From: [REDACTED]
Sent: 29 August 2026 23:34
To: Planning
Subject: 3/2026/0356 - Objection

I strongly object to planning application 3/2026/0356, Land at Hammond Ground, Whalley Road.

From: Planning
Subject: FW: Hammond Ground, Read - 3/2026/0356

On [REDACTED], I wish to bring to your attention that the arboricultural report and plans which accompany the above application date from March 2024 and are therefore significantly out of date. Perhaps of more concern is the fact that the submission contains no Arboricultural Impact Assessment, no Arboricultural Method Statement and no Tree Protection Plan. Effectively, there is no assessment of the development's impact on the trees. The tree plans themselves do not even show the proposed development, so they cannot demonstrate the relationship between the submitted scheme and the trees, the root protection areas, or the constraints the development must respect. As a consequence, it is difficult to understand how the Council can begin to properly assess the arboricultural impact of this 77 dwelling scheme when the tree report has not been fully arboriculturally assessed against the detailed layout. It has been suggested to me by an Arbor

Drawing file: planx_downloads / 26_0356_Tree_Survey_2_of_3.pdf

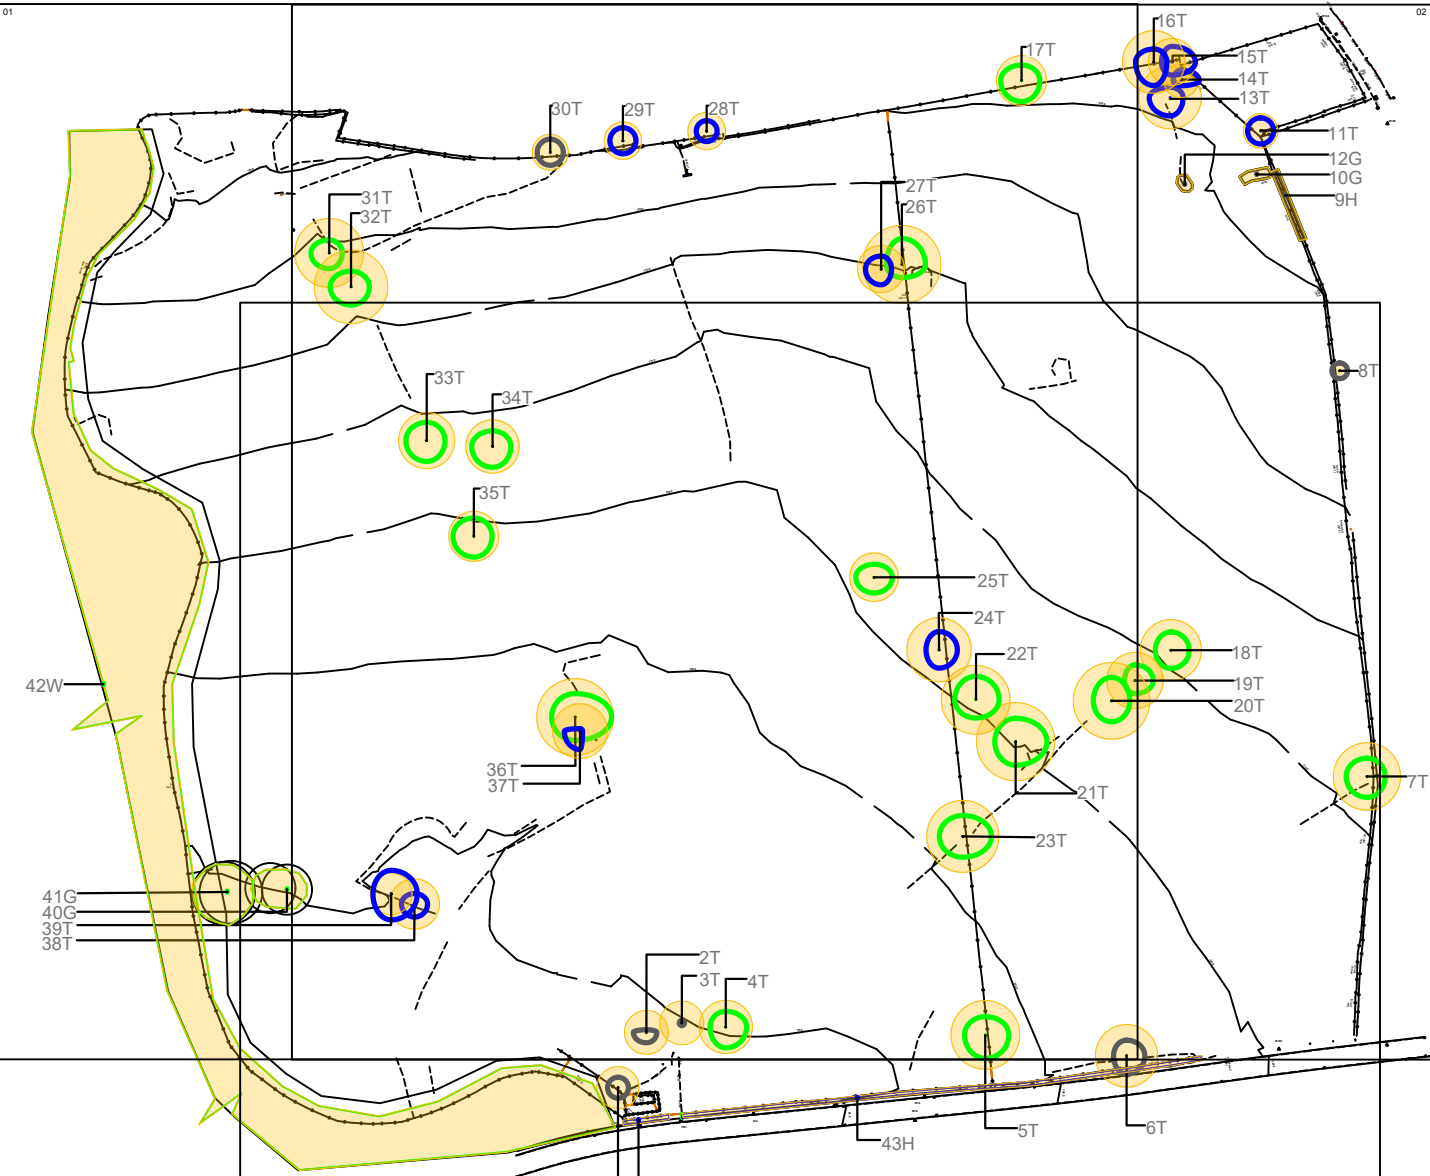
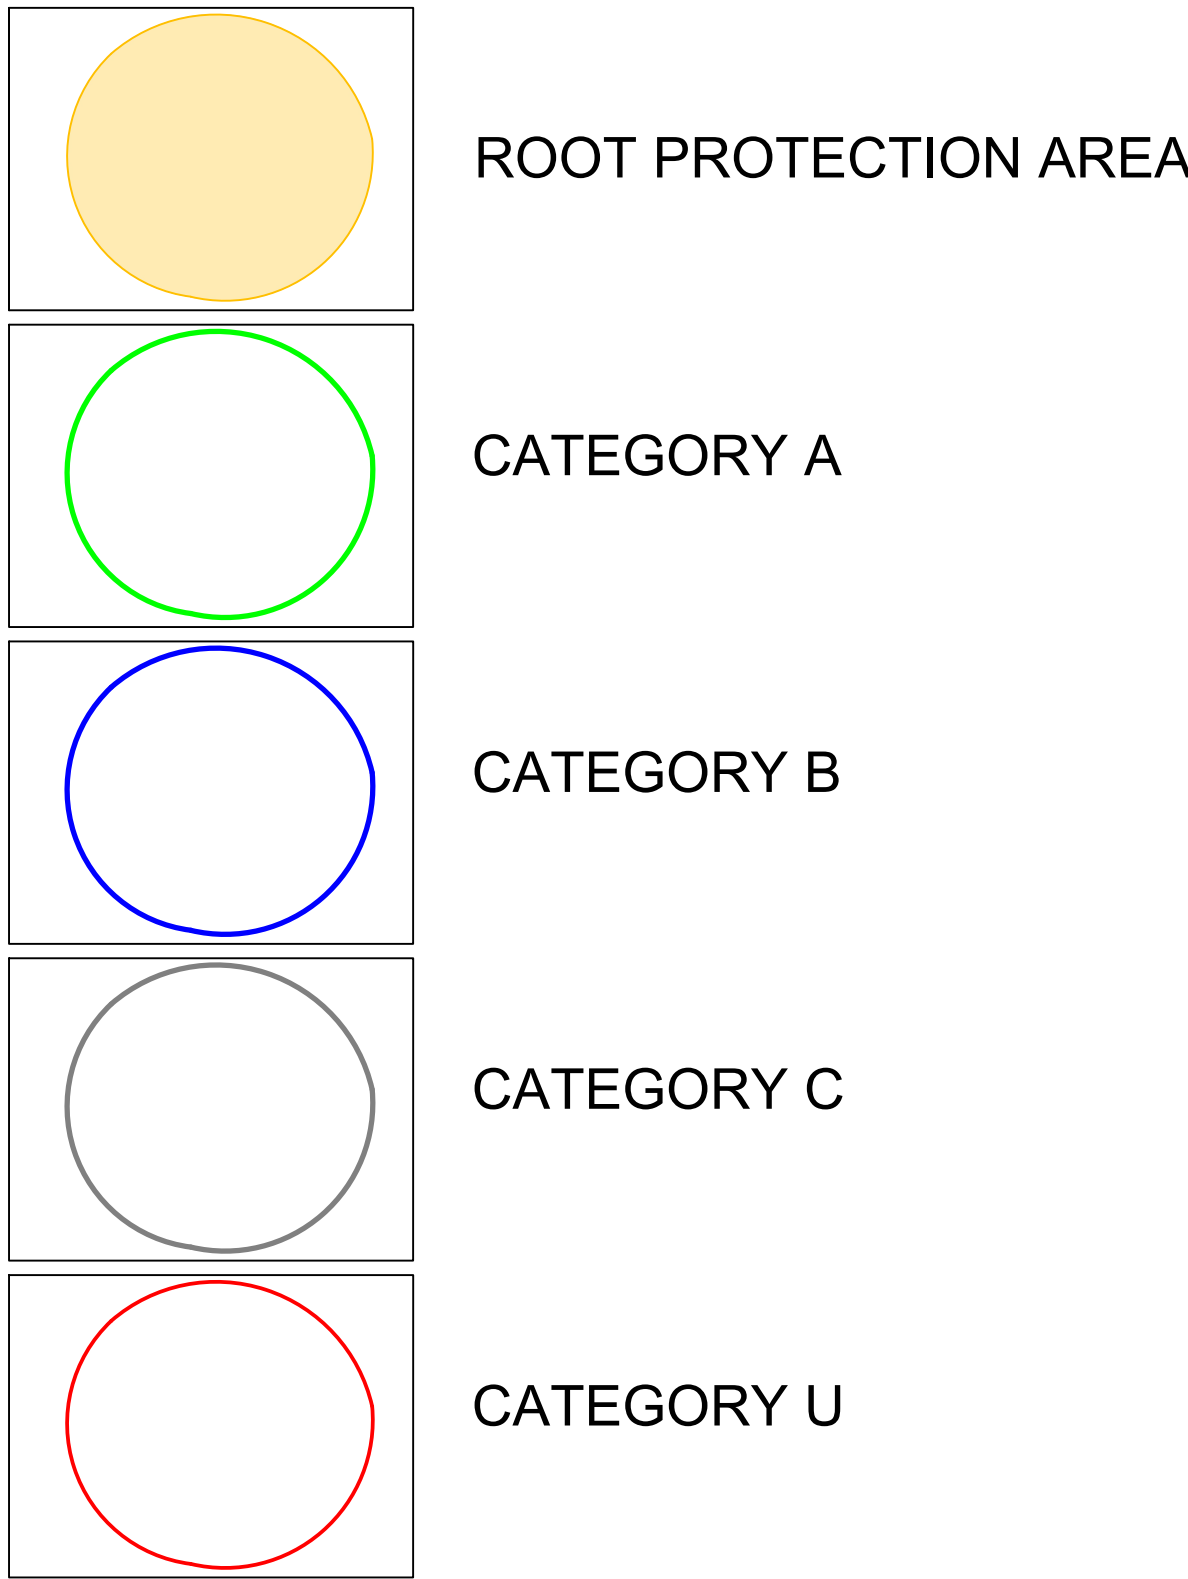
Furthermore, if a thorough arboricultural assessment cannot be completed due to lack of the necessary evidential base then this in turn potentially impacts the ecological assessment, the biodiversity net gain metric and proposed mitigation of planting. It follows through therefore, that if the underlying tree data is out of date and no proper impact assessment has been carried out then logically the BNG calculations and mitigation scheme built upon this baseline information cannot be relied upon either. I am also aware that there are requested changes from LCC Highways in respect of the access to the site which could have a further impact on some of the existing tree cover together with resultant loss in mature frontage hedgerow which at this stage is difficult to quantify until a more detailed revised access scheme is submitted. This again will undoubtedly have a resultant negative impact on the BNG metric, not to mention the visual impact on the street scene and ecological baseline.
